Laurie Leader - 54 Roundabout Lane -Constantine residence _renovations

From: Charles Young <cyoung@rrennerarchitects.com>
To: Laurie Leader <LRL@portlandmaine.gov>
Date: 7/28/2015 10:05 AM
Subject: 54 Roundabout Lane -Constantine residence _renovations
CC: Teresa Telander <ttelander@rrennerarchitects.com>, Rick Romano <rick@pap...>
Attachments: 2014-11.00_L1.1_Site Plan.PC9.pdf; 2014-11.00_A1.1_FirstPlan.PC9.pdf; 2014-11.00_A2.1_Elevation W and Section.PC9.pdf; 2014-11.00_A2.2_Elevations.PC9.pdf

Please find attached the revised drawings in response to your preliminary zoning and building review comments for 54 Roundabout Lane.

A1.1

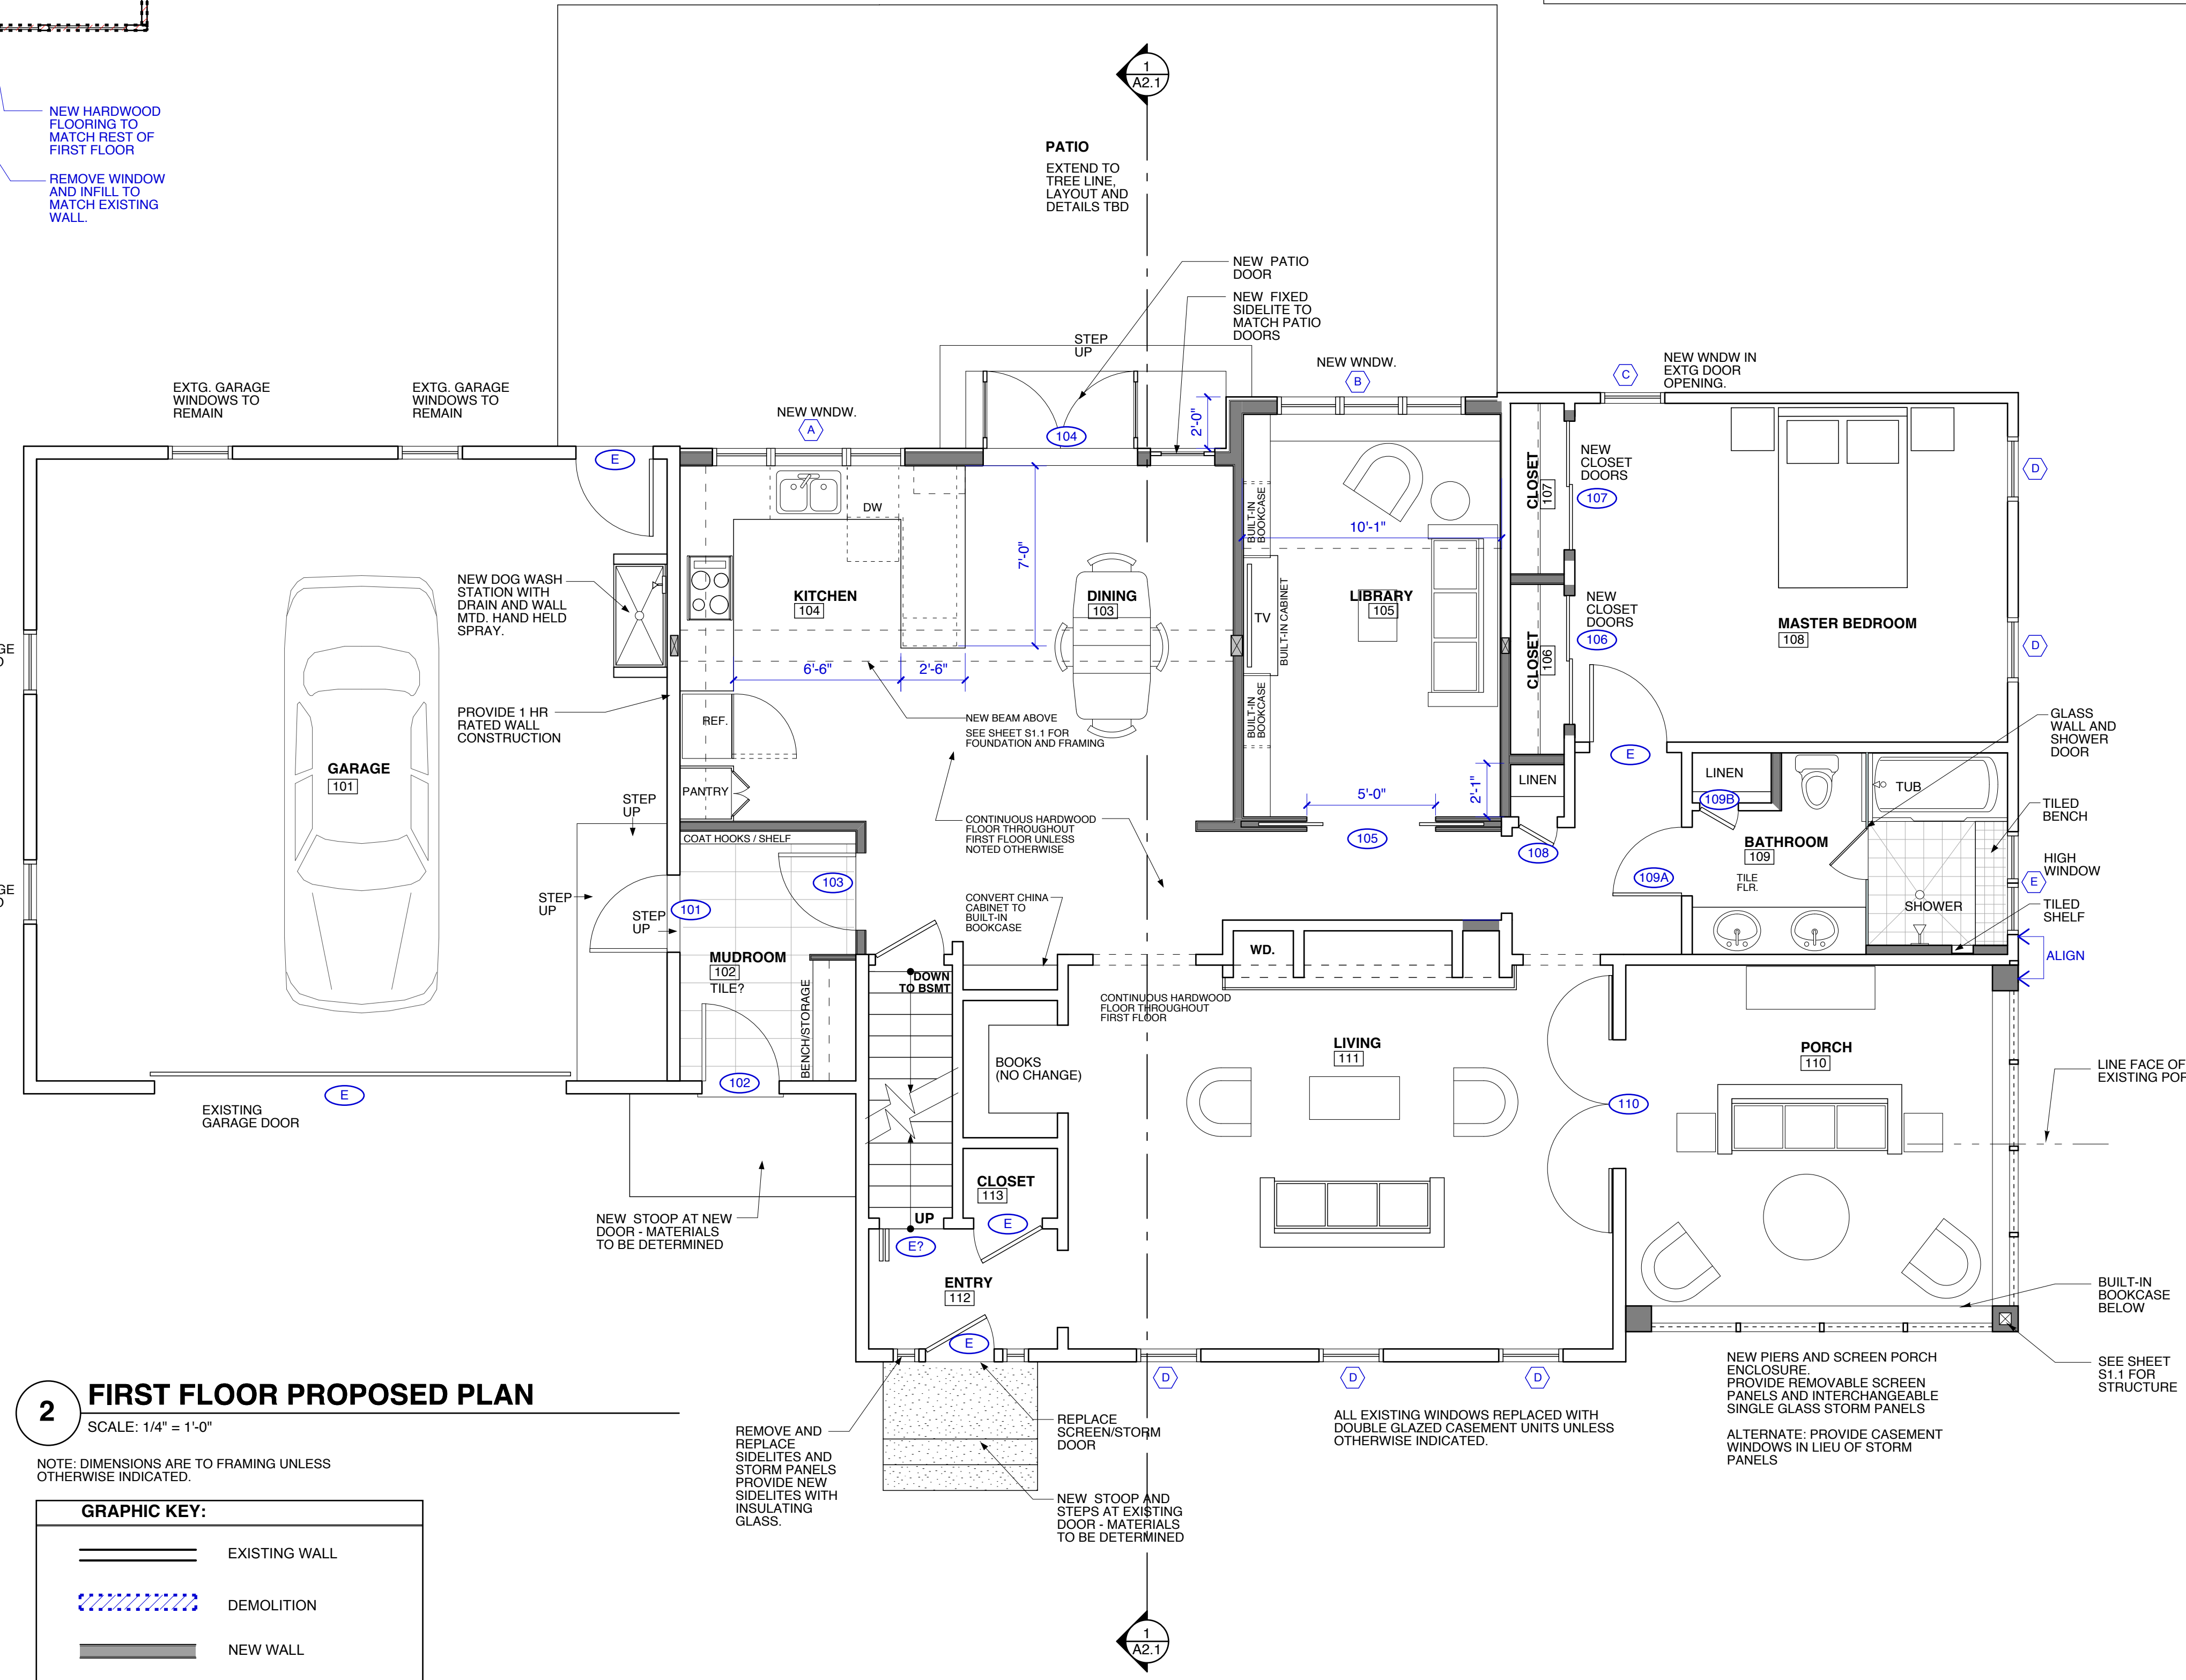
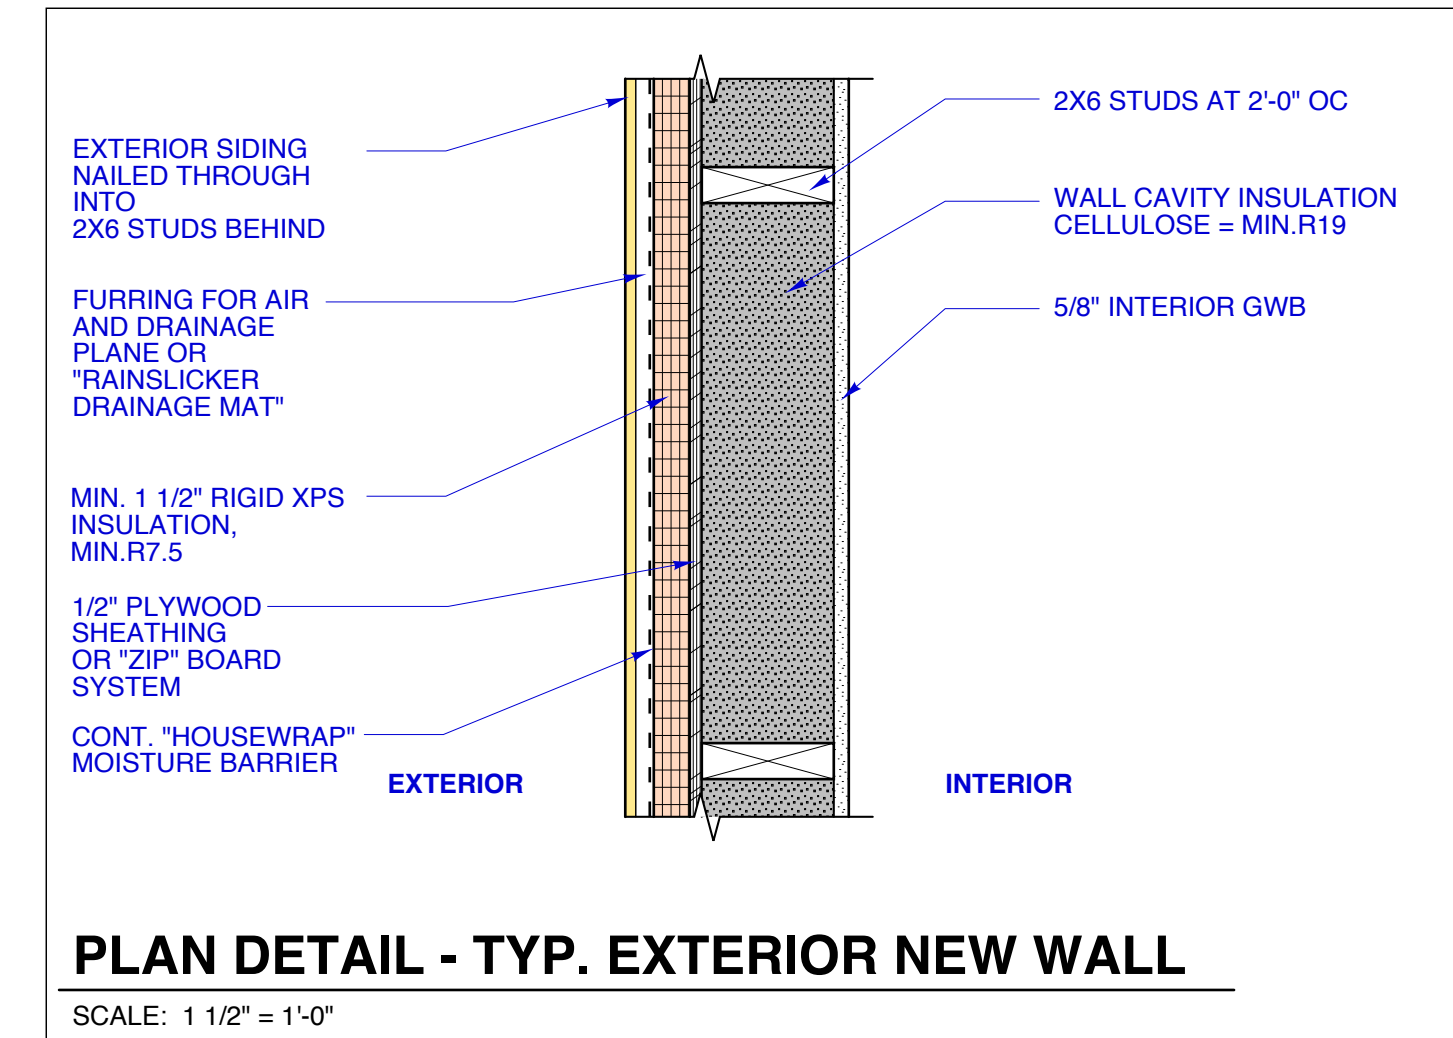
With regard to the comment on sheet A1.1 about the need to provide deck attachment per IRC code R502.2.2.3 we are providing the following response from our structural engineer, Joe Leasure.

"The City of Portland comment on the Constantine Dresser project located at 54 Roundabout Lane, Portland requesting to "Provide attachment detail from deck/new addition to dwelling unit per 2009 IRC figure R502.2.2.3" which requires installation of a "Hold-Down or Similar Tension Device" is not applicable and unnecessary for the porch extension framing system. The floor framing is an extension of existing floor framing that is attached to the exterior wall with an existing connection that we did not expose nor review as it was not affected by the proposed addition. Secondly, and more importantly, the intention of the figure R502.2.2.3 code requirement is to prevent the floor/deck from "pulling away" from the exterior wall structure and/or adversely affecting the ledger connection, which is resolved by other structural systems in this case. The existing and new porch floor system is fastened to two perpendicular exterior walls which brace the porch floor and resists lateral loads in any direction. Lateral loads are resisted in shear and/or compression. Hence, the "Hold-Down or Similar Tension Device" referenced in 2009 IRC figure R502.2.2.3 is unnecessary."
